Please add PCD File No. *EGP-213*

PEACEFUL RIDGE AT FOUNTAIN VALLEY
FINAL GRADING PLAN
GRADING AND EROSION CONTROL PLAN
EL PASO COUNTY, COLORADO

Project No.: 04092/21031
Date: October 4, 2021
Design: JGD
Drawn: MJK
Check: AJWC
Revisions:

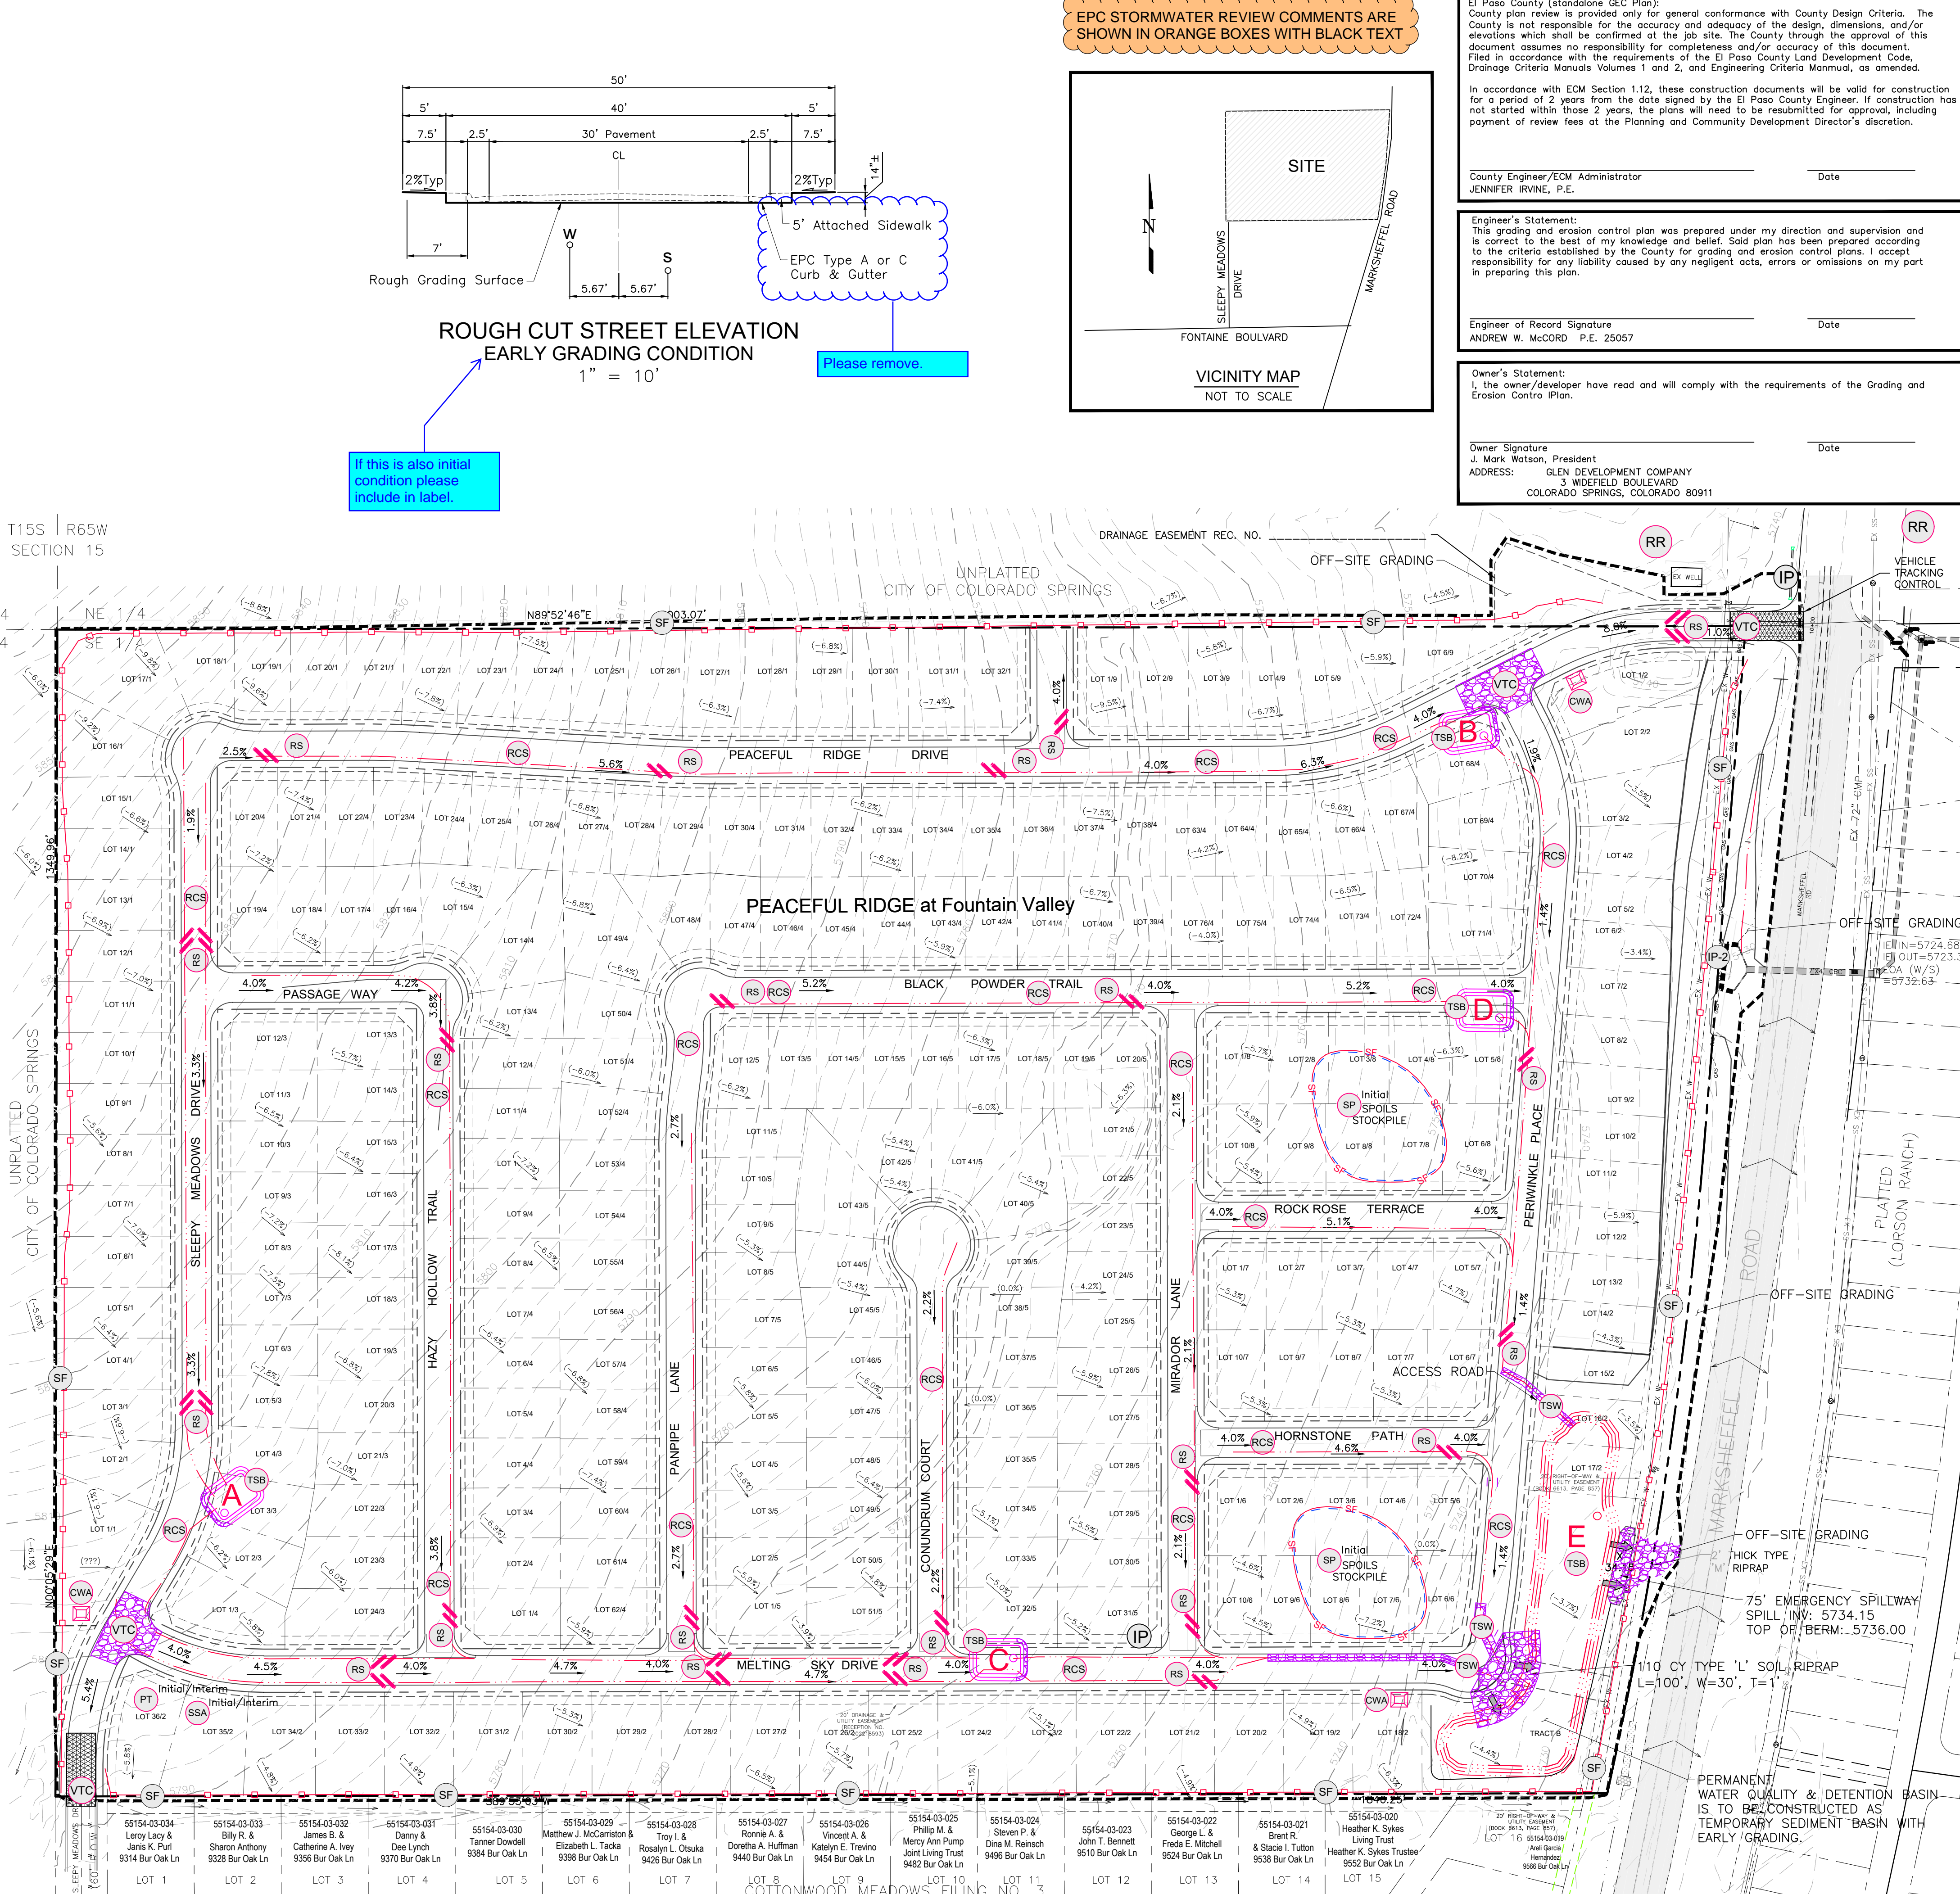
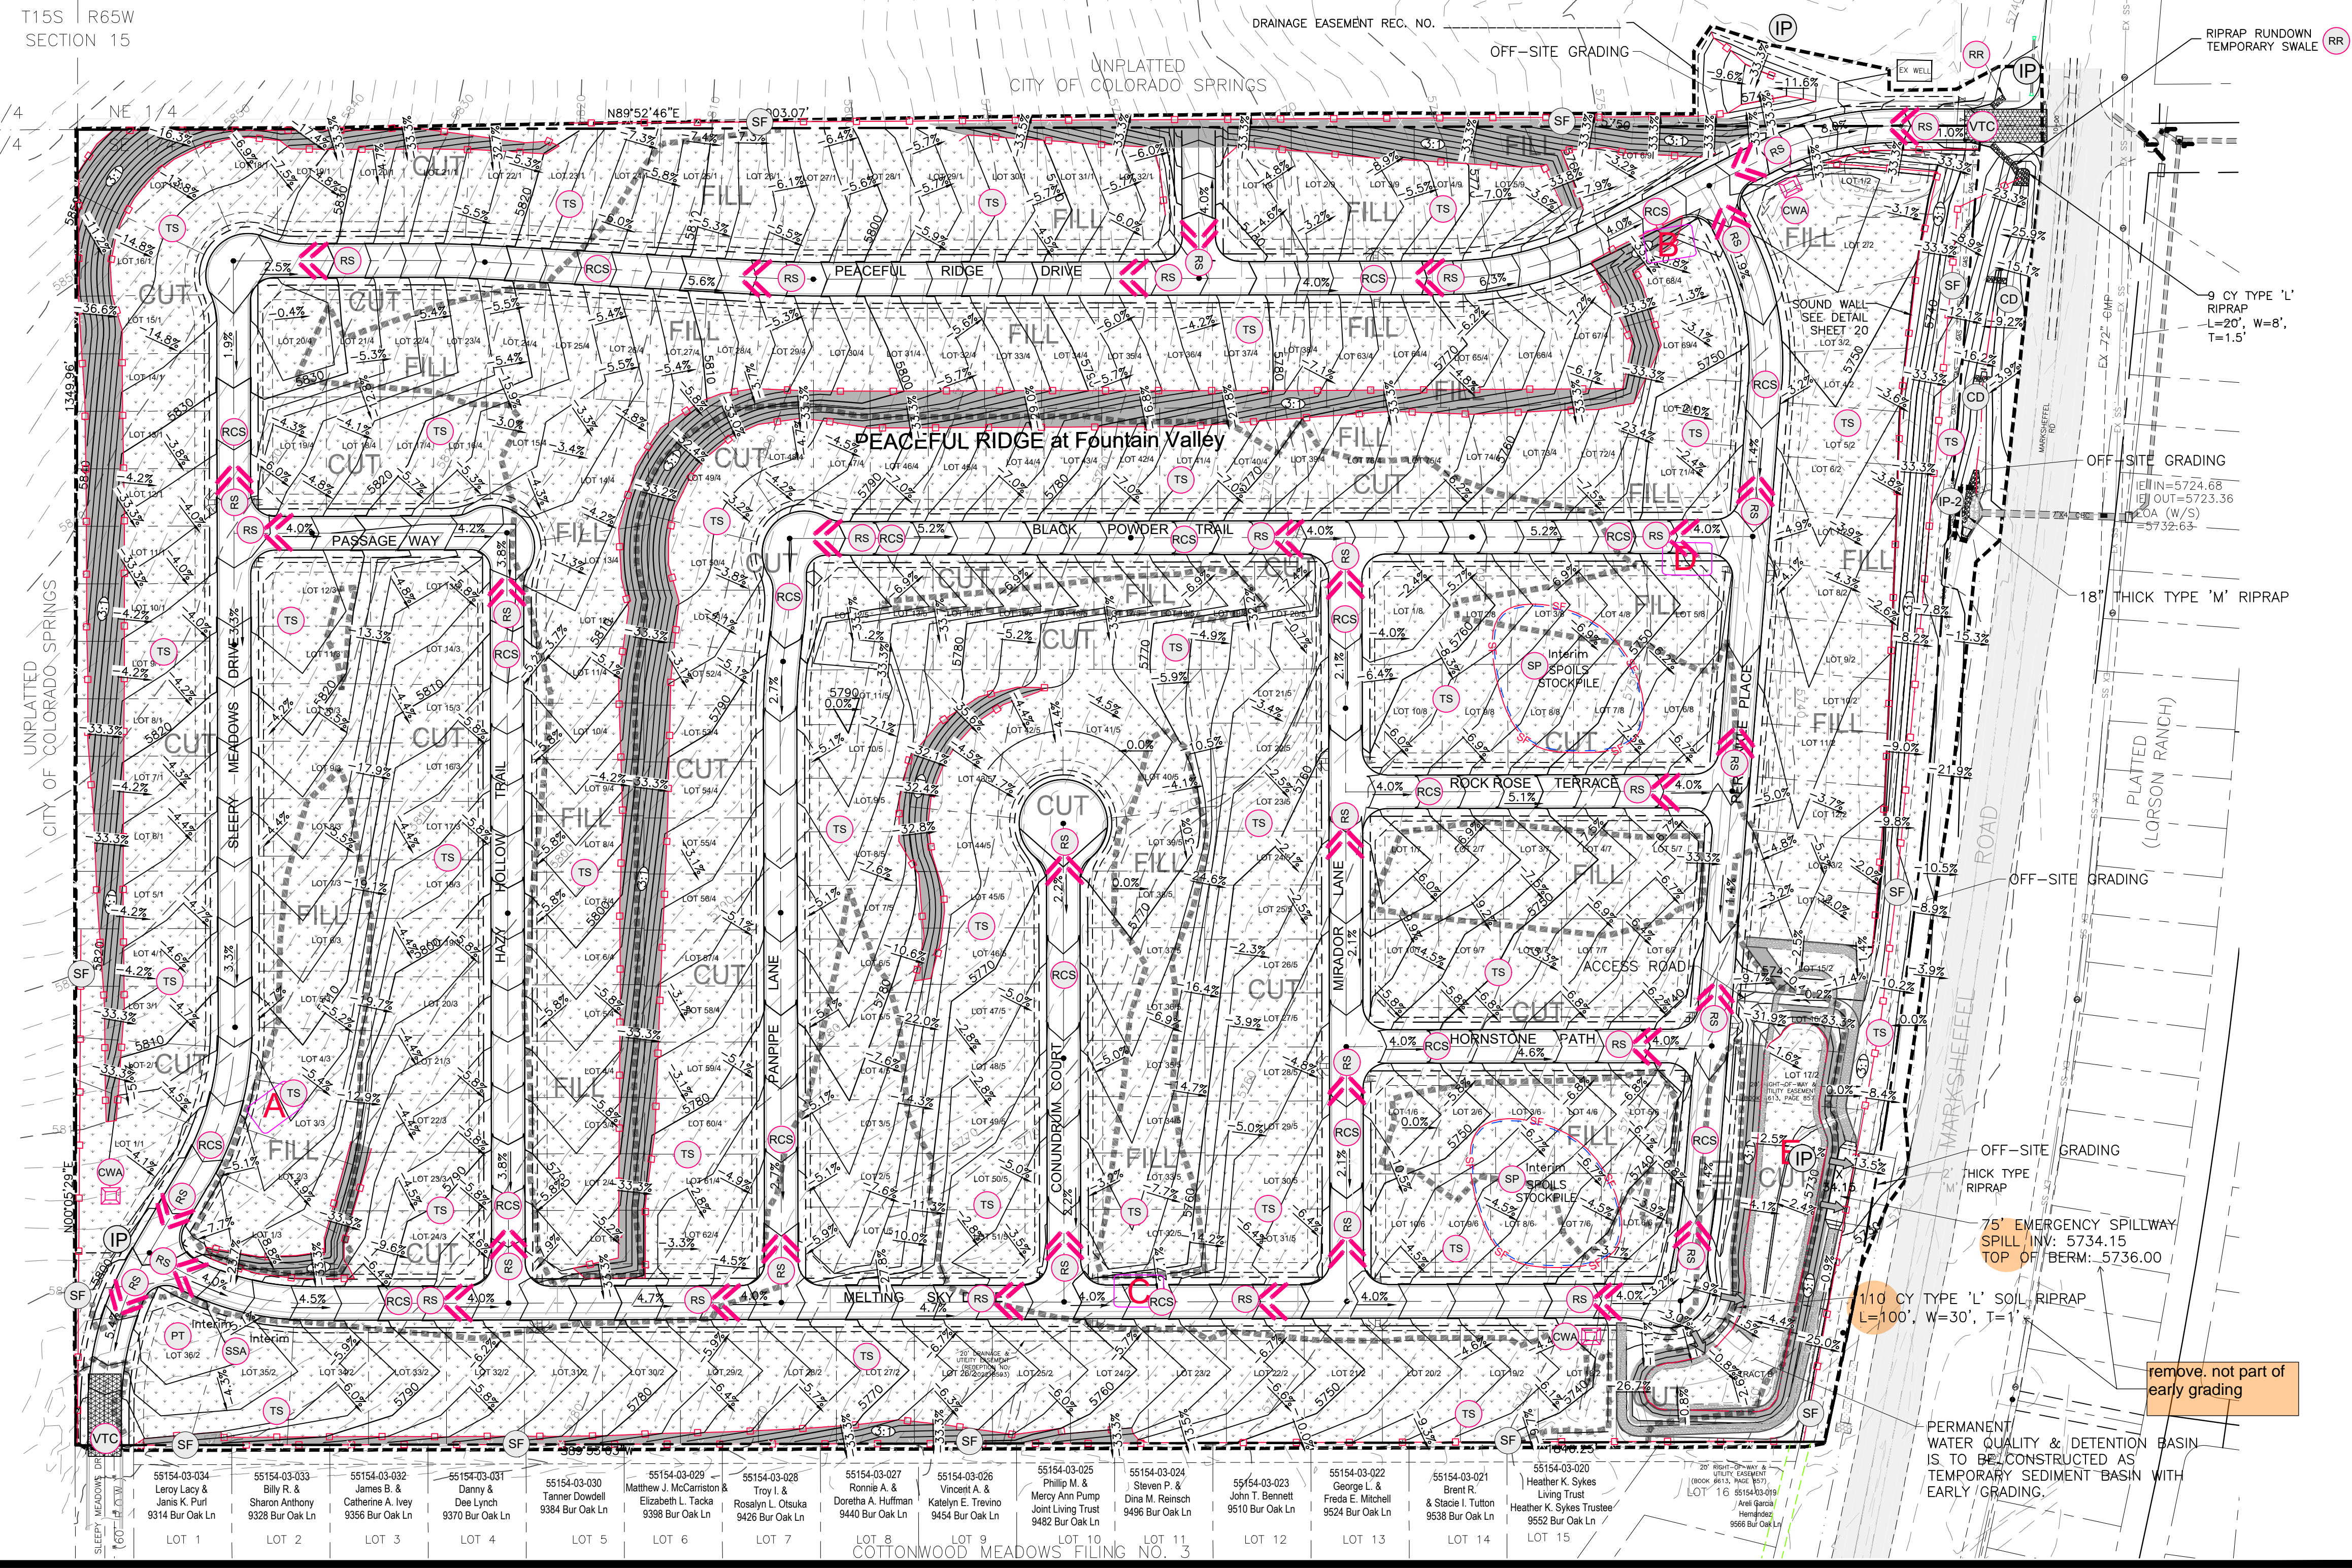
show stormwater flow arrows for existing and proposed conditions. show temporary construction control measure details.

Show construction boundary. If "limits of disturbance" and "construction boundary" are the same, change to "limits of construction/disturbance" or otherwise show as separate line types for each on the legend and figure.

Please include cross sections for roads that show road cuts and final road configuration along with elevations.

SF should be moved down to capture all disturbance in this area
